CITY OF ALBUQUERQUE

July 31, 2013

RE: **Morrison Supply – Warehouse, 301 Indiana SE**
Grading & Drainage Plan for Building Permit
Tract 6-A-1, Block 14, Fairgrounds Addition

File **K18-D021**
PE Stamp: 6/21/13

GRADING & DRAINAGE PLAN

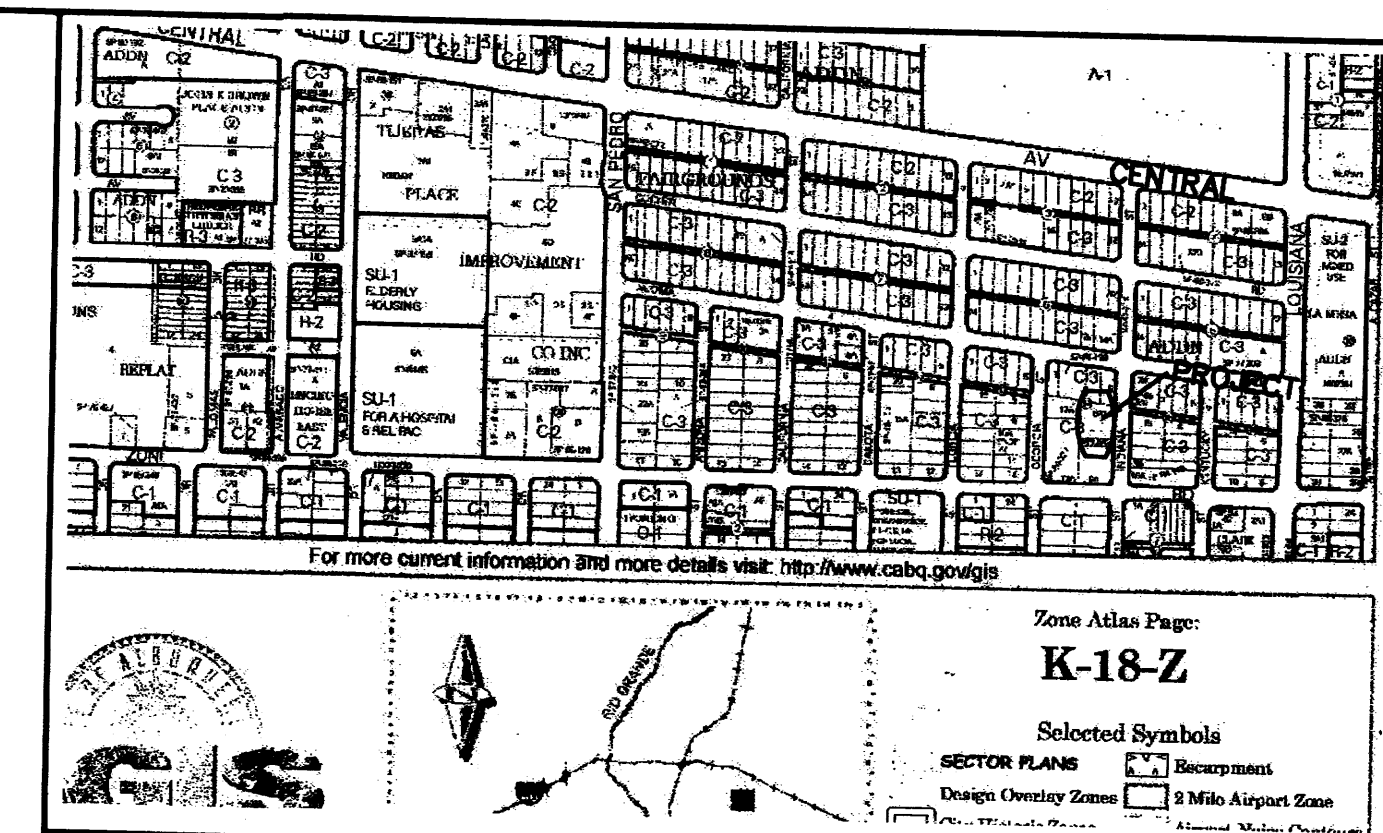
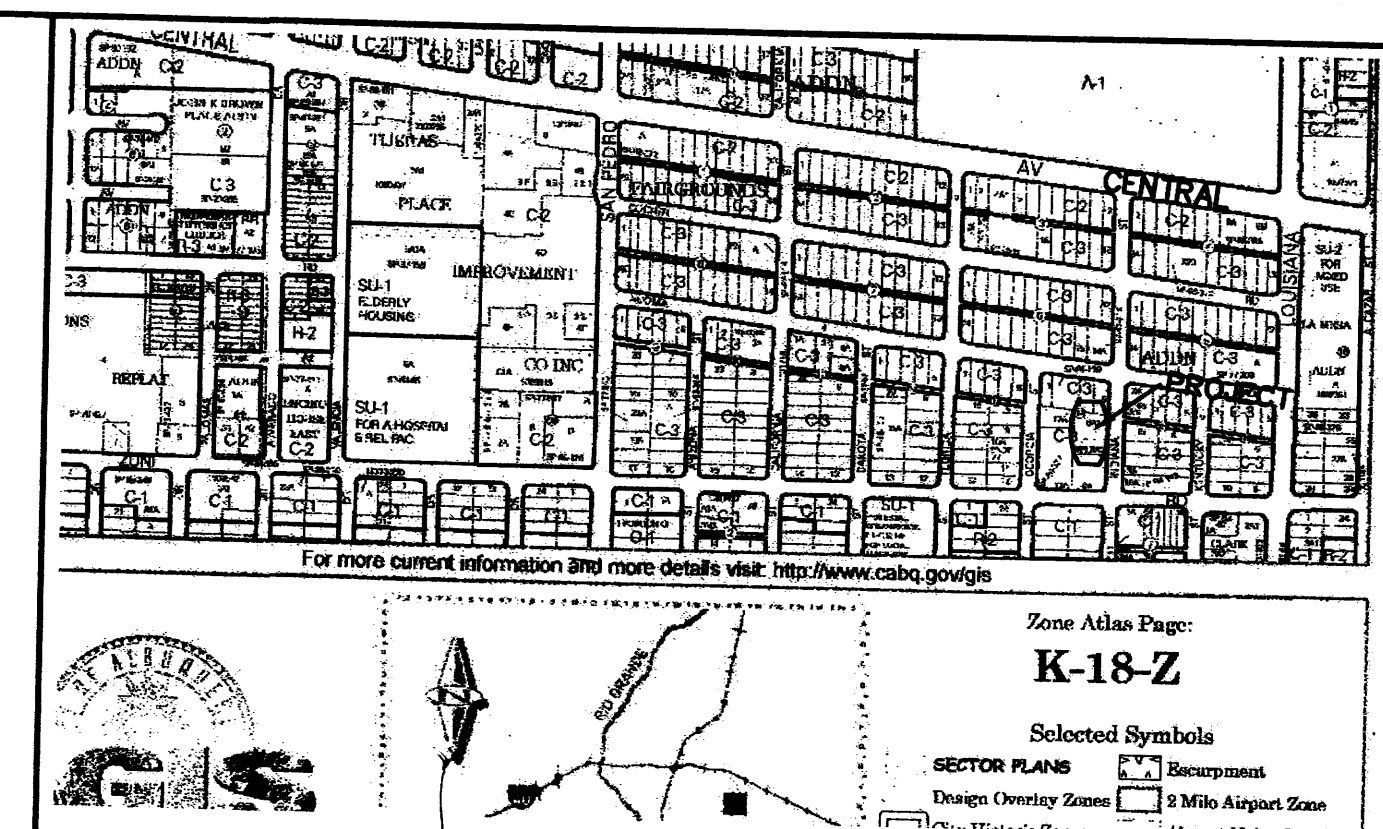
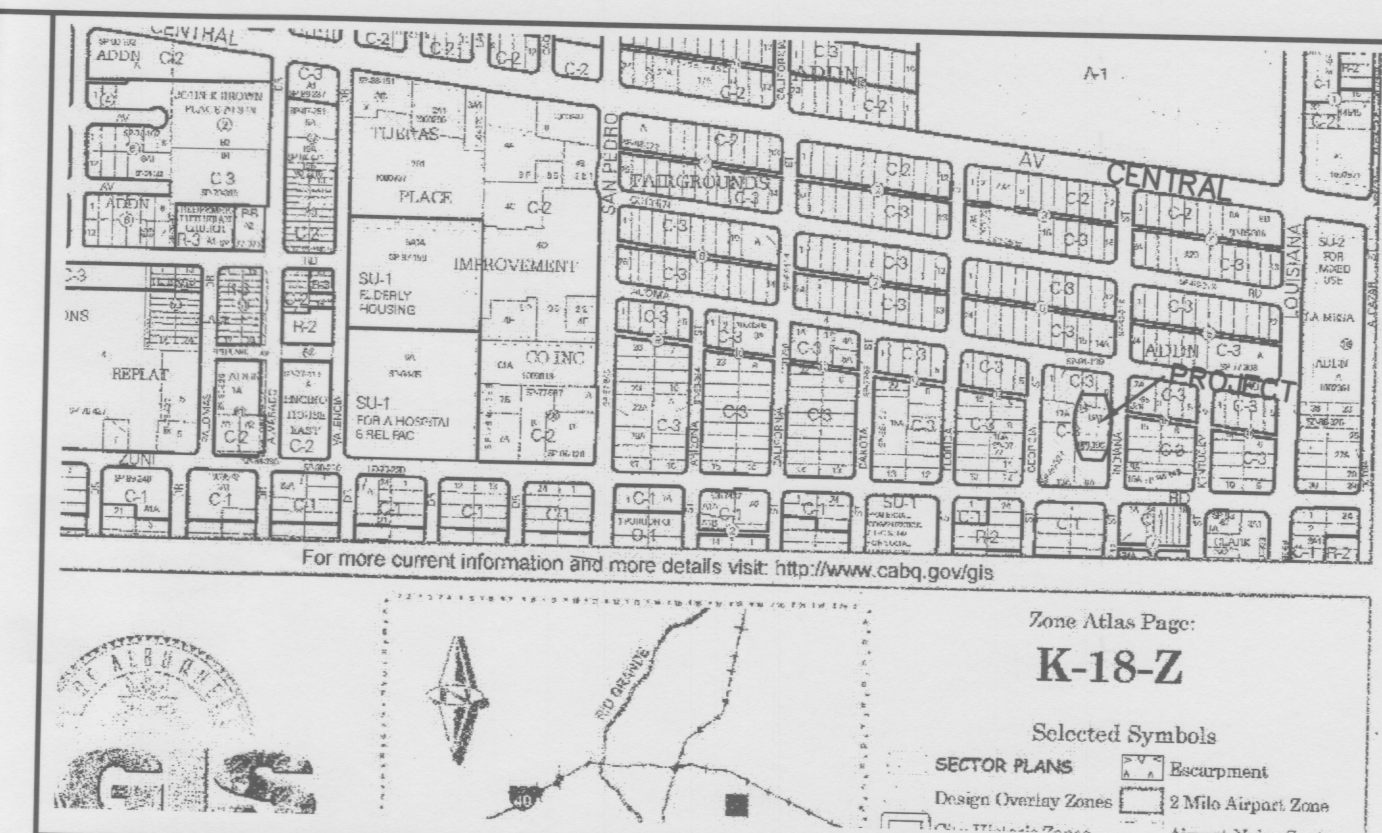
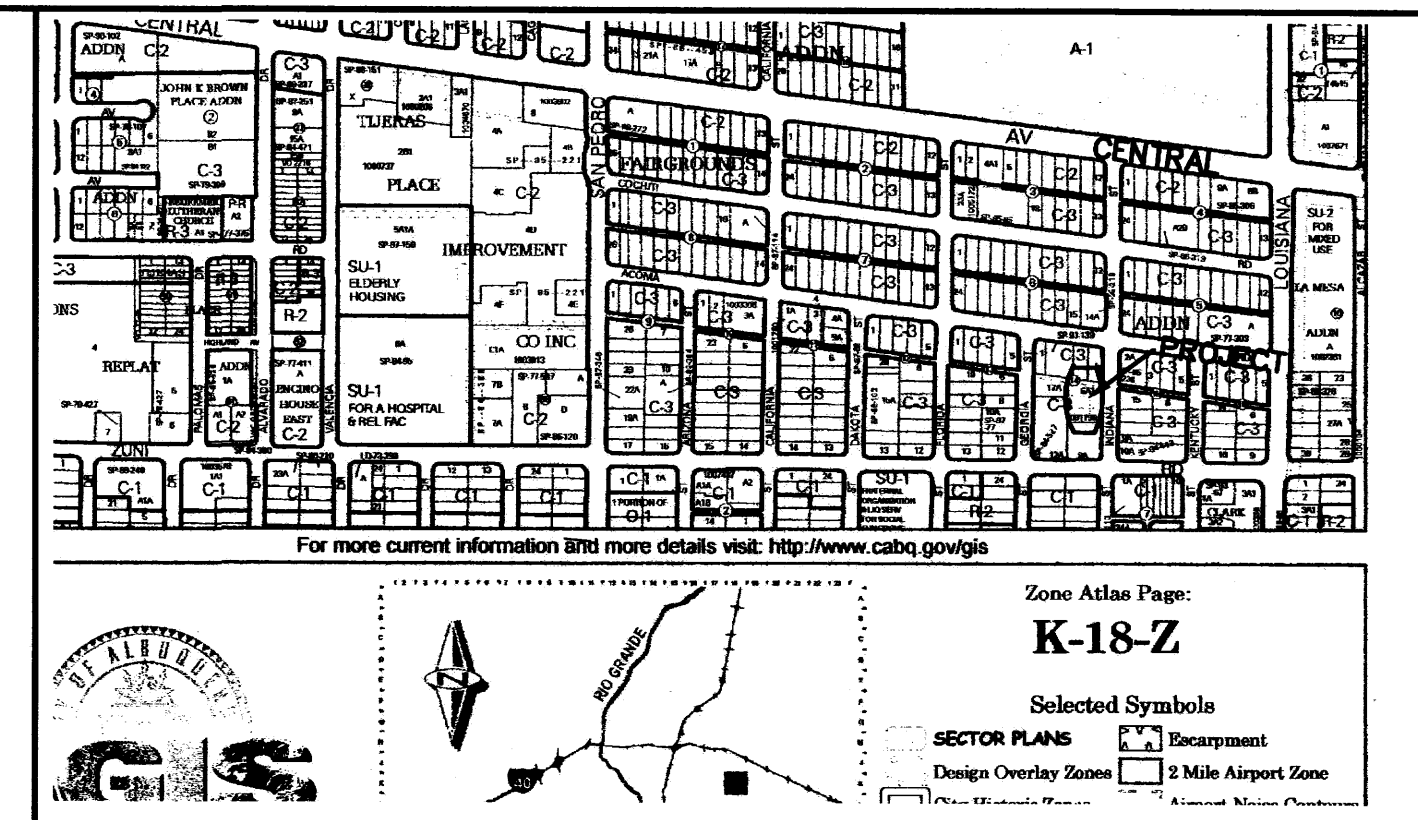
1. The drainage plan does not recognize off-site flows from the NE corner of Lot 9-A. Grades provided indicate roughly 0.10 acre of that lot discharging to this site.

2. This plan shows a loading bay / ramp, west of the building, which acts as a sump for runoff from the southern 25% of the site paving. Provide pump calculations to show that flows intercepted at this point are conveyed to the harvesting pond, as shown, and are not allowed to overflow to Tract 12A at elev. 9.50.

3. Is the 8" force main intended to run under the building pad? The Referenced Mech. Plan was not provided with this submittal. (7/31 revision to 4" line around building appears ok)

4. Provide sizing of the sump pump(s) to discharge to the eastern pond. (Your 7/31/13 proposal of a Zoeller 268 Pump appears undersized.) Provide calculations of runoff entering the sump in the design storm, and size pump(s) and pipe accordingly.

5. Provide documentation of the Construction Easement and Access Easement necessary to support the ramp construction and operation on Tract 12A.
6. Clarify the point and direction of overflow from the water harvesting pond, on the east edge of the site. Will flows exist through the old alley entrance, northeasterly to Indiana Street, or will they drain westerly in the vacated alley corridor?

7. Sub-basin boundaries would be helpful in quantifying proposed run-off.

8. This plan has a note to “ENSURE 0.3’ INVERTED CROWN AND POSITIVE DRNG, TO GEORGIA” in the Private Surface Drainage Easement (Vacated Alley) along the north edge of Lot 17-A. Provide survey to verify this, or contours and additional spot elevations for grading of the drainage corridor. In my 7/30/13 field visit, I observed the old alley corridor to be heavily obstructed by material/equipment storage, potentially causing a mid-block diversion of runoff flows to private property on the north side of the easement. This plan and construction must confirm the outfall capacity to Georgia and/or Indiana St.
